From: Laura Gibbons
Sent: 02 April 2019 08:34
To: Planning.Responses
Cc: Anita Gardner
Subject: RE: Planning Consultation on FG/32/19/DOC

Engineers Comments Regarding Condition 3

APPLICATION NO: FG/32/19/DOC

Description of Works: Approval of details reserved by condition imposed under ref FG/39/18/PL relating to Condition No 3 surface water drainage.

YEO AKSW XX GF DR C 9205

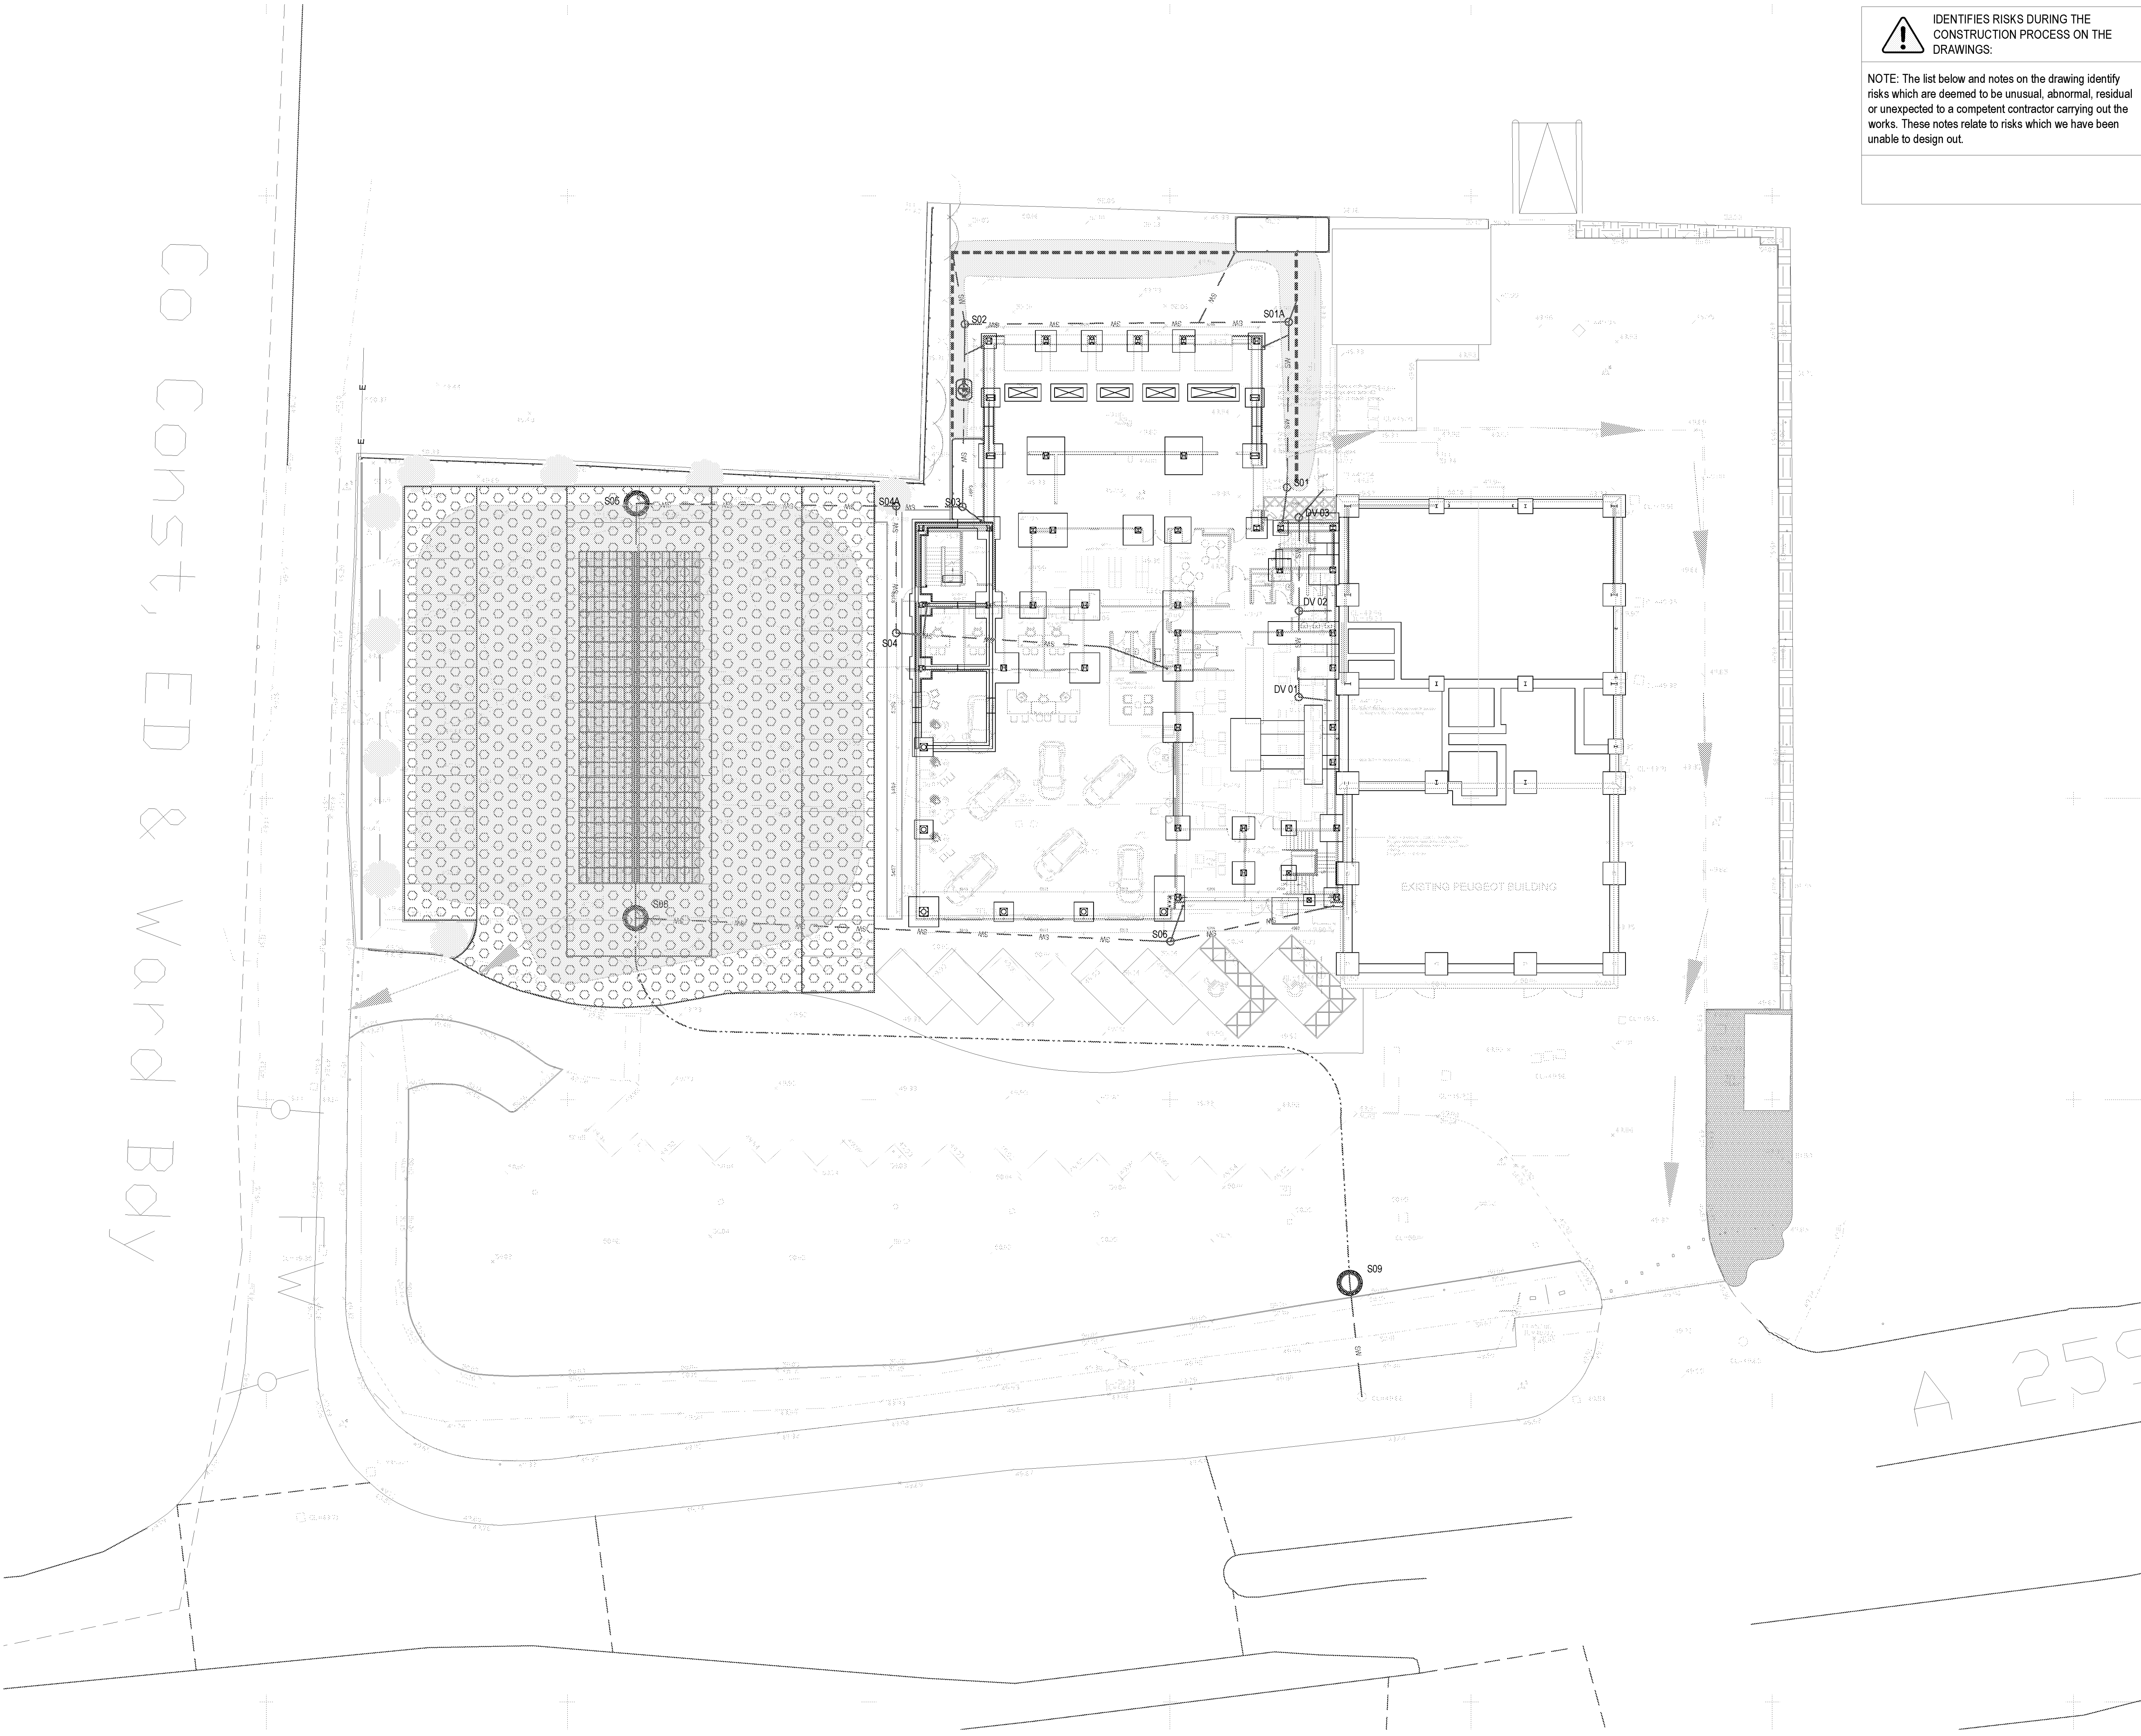
The proposals on the planning portal are for attenuation and discharge into a highways drain. This is not appropriate. Furthermore, groundwater levels are insufficient to justify this. As a result, the applicant is currently developing proposals for a shallow infiltration solution.

I will provide further comments when the revised proposals are submitted.
